Application Ref:
73195/APP/2017/3486

High Speed Rail (London - West Midlands) - Schedule 17 - Planning Work

Plans and Specifications submission under Schedule 17 of the High Speed Rail (London - West Midlands) Act 2017 for an ecological mitigation scheme comprising earthworks, including two mitigation ponds, one hibernaculum and one reptile bank, together with permanent fencing erected along the northern, eastern and southern boundaries of the site.

Location of development: Ecological Mitigation Site, Harvil Road, Harefield,

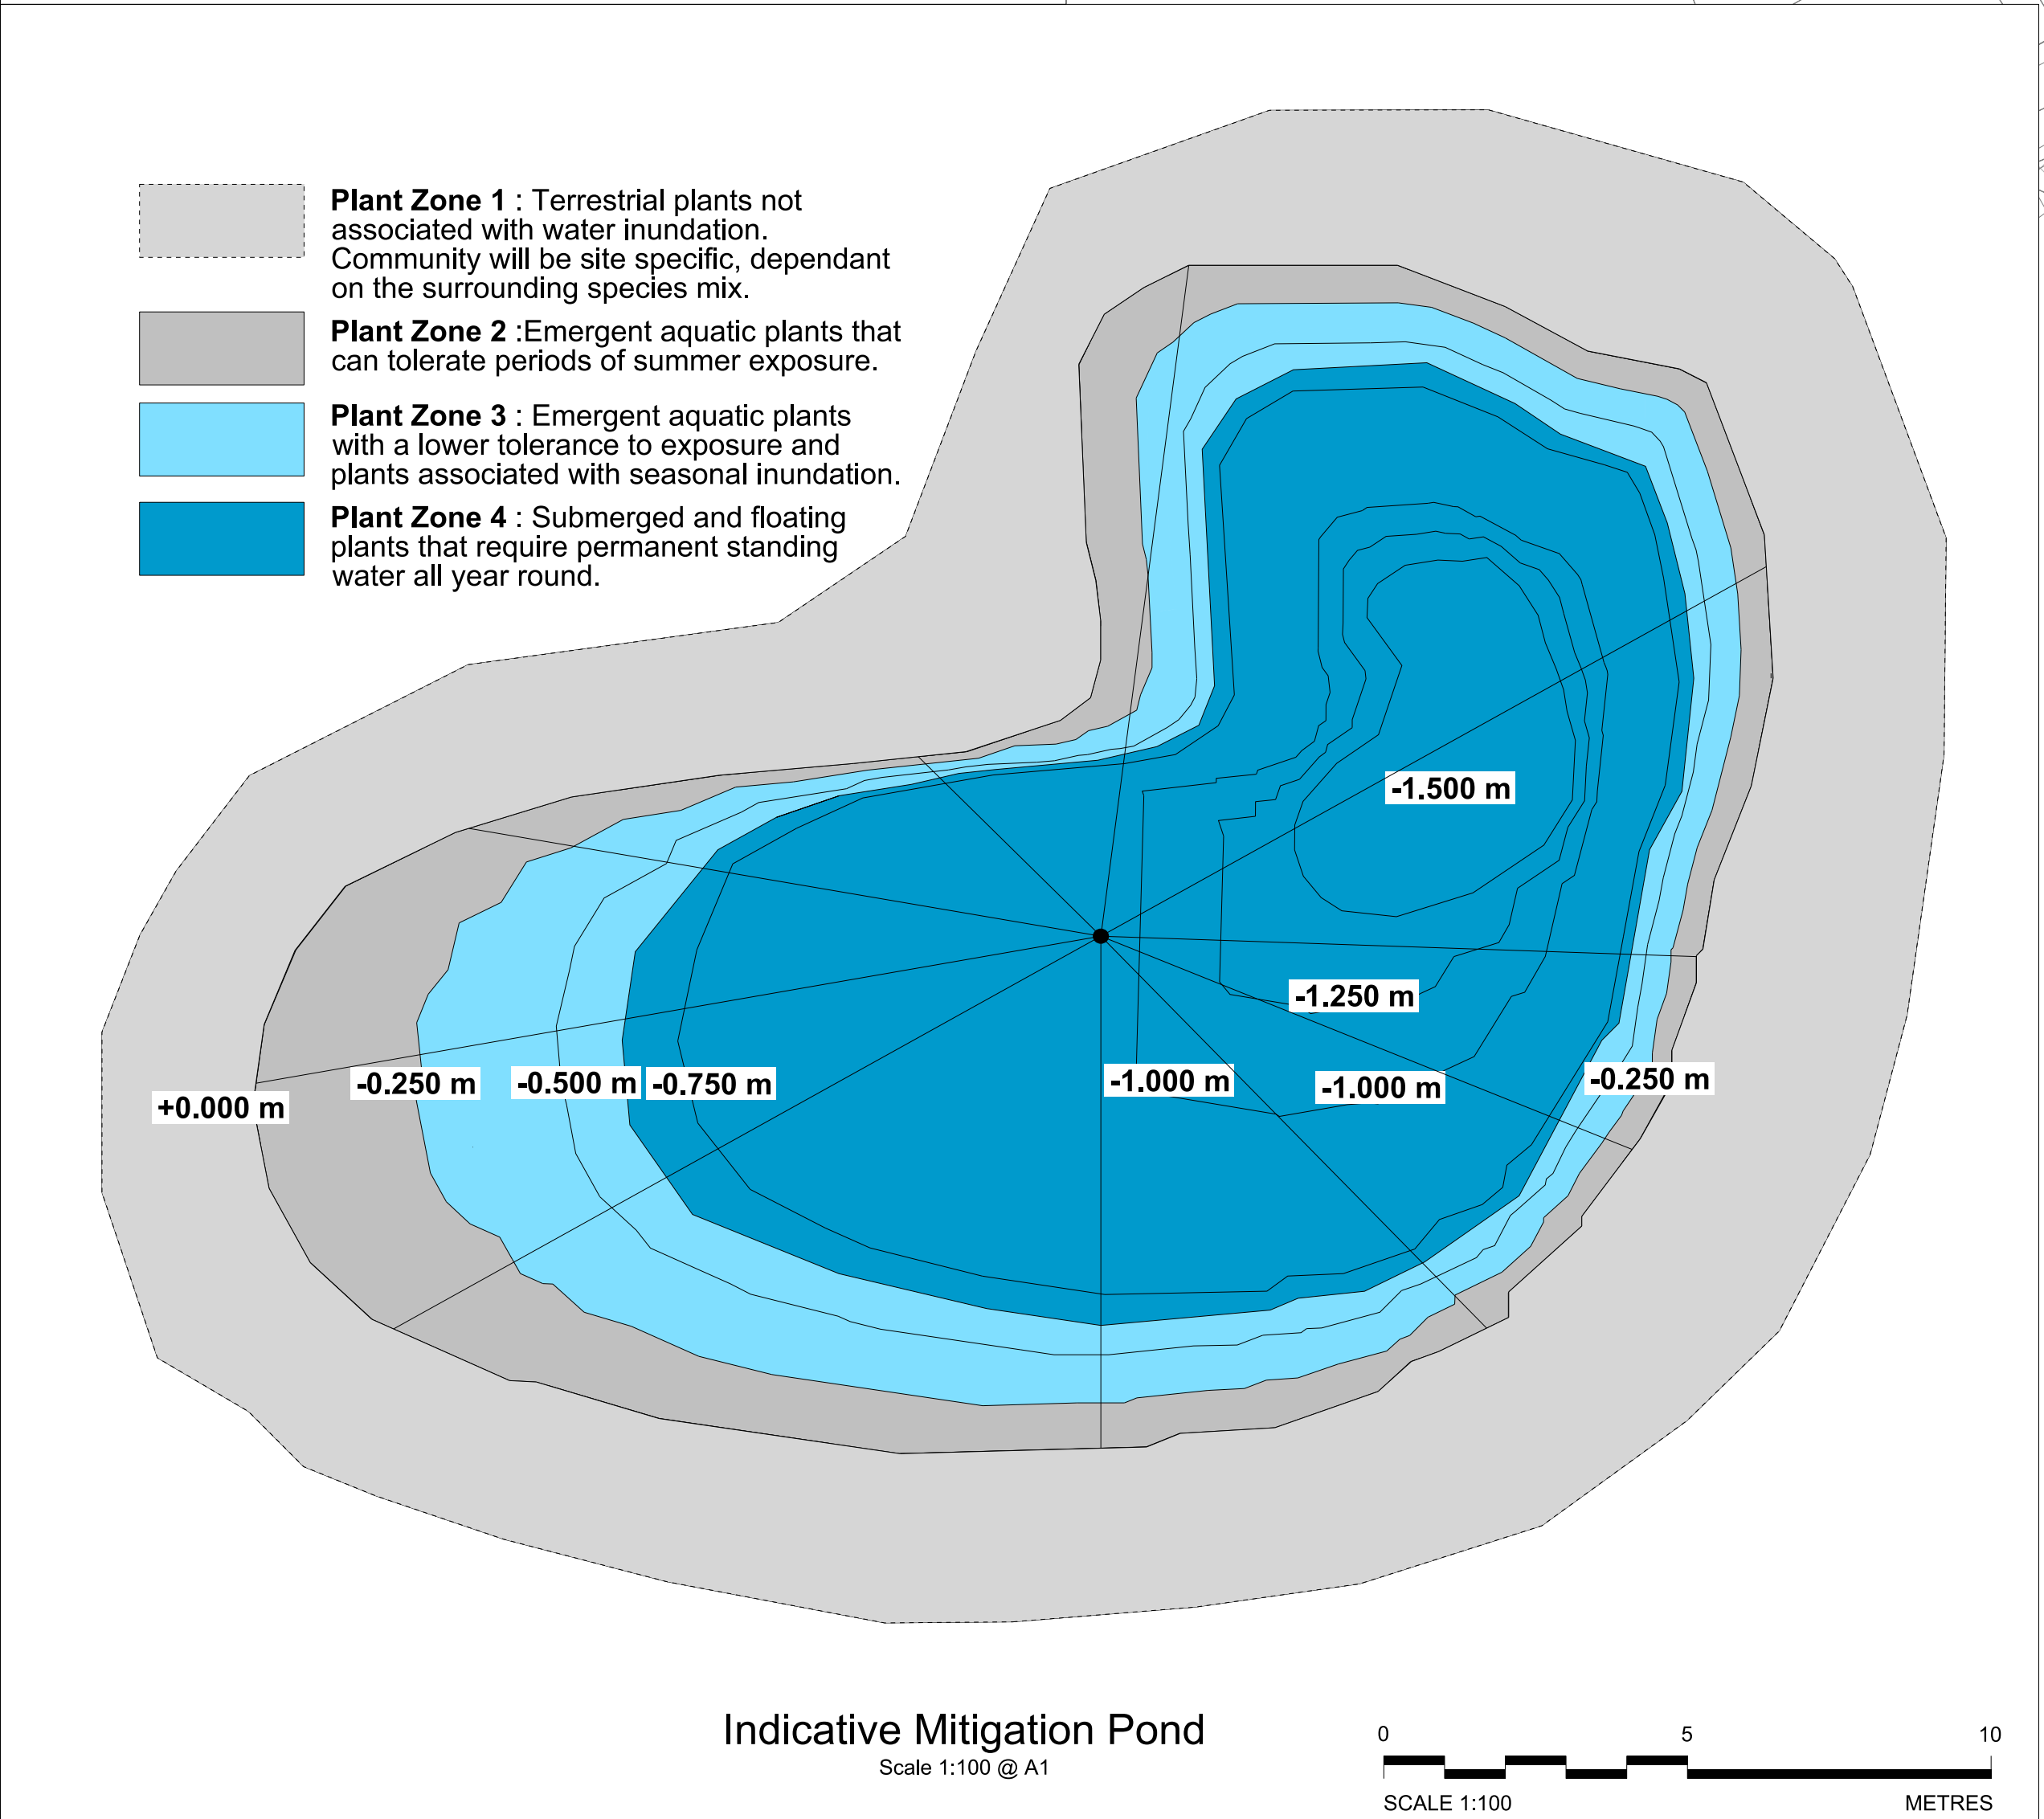
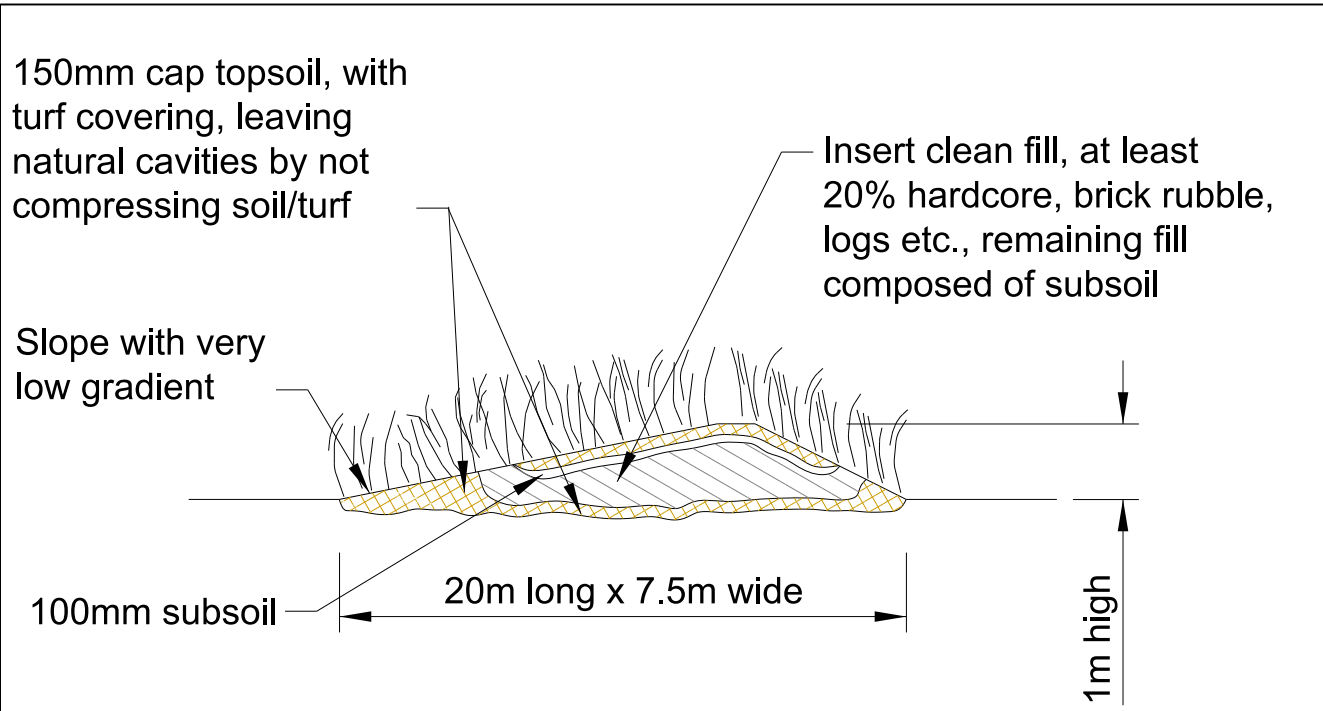
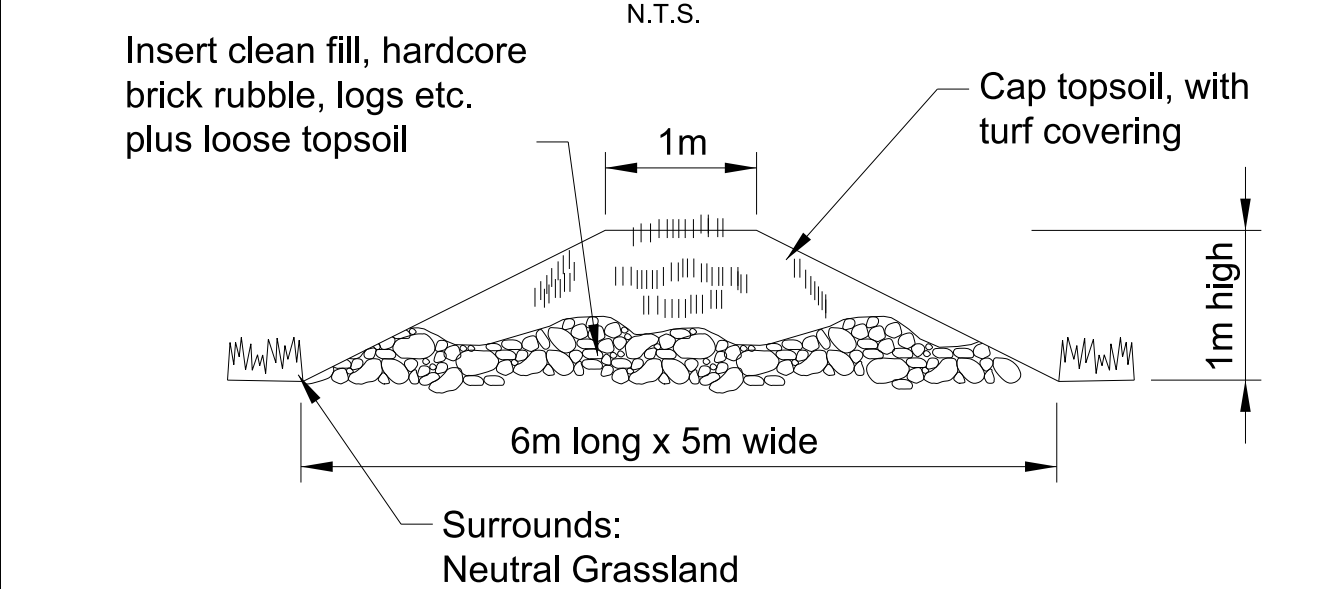
The Council does not consider the details relating to landscaping, ecological planting and site restoration are adequate as presented. The information submitted is not adequate to fully understand what HS2 Ltd is trying to deliver by way of landscaping or restoration. The restoration package needs to be far more detailed prior to the Council confirming the approach is adequate.

- Pond lining (puddled clay preferred);
- Soft landscape proposals include schedules, specifications and appropriate planting plans;
- Management and Maintenance plans and schedules;
- Landscape details (fences , gates, tracks and ancillary works);
- The inclusion of species rich hedgerows in place of the proposed hard fencing to reflect the setting in the Green Belt and existing features of ecological importance;
- Long term access arrangements for maintenance;
- Site security measures;
- Ecological enhancement plan showing the interaction of the site with the surrounding area;
- Detailed proposals for land ownership and responsibilities; and
- Detailed information on how the pond will be filled and levels maintained.
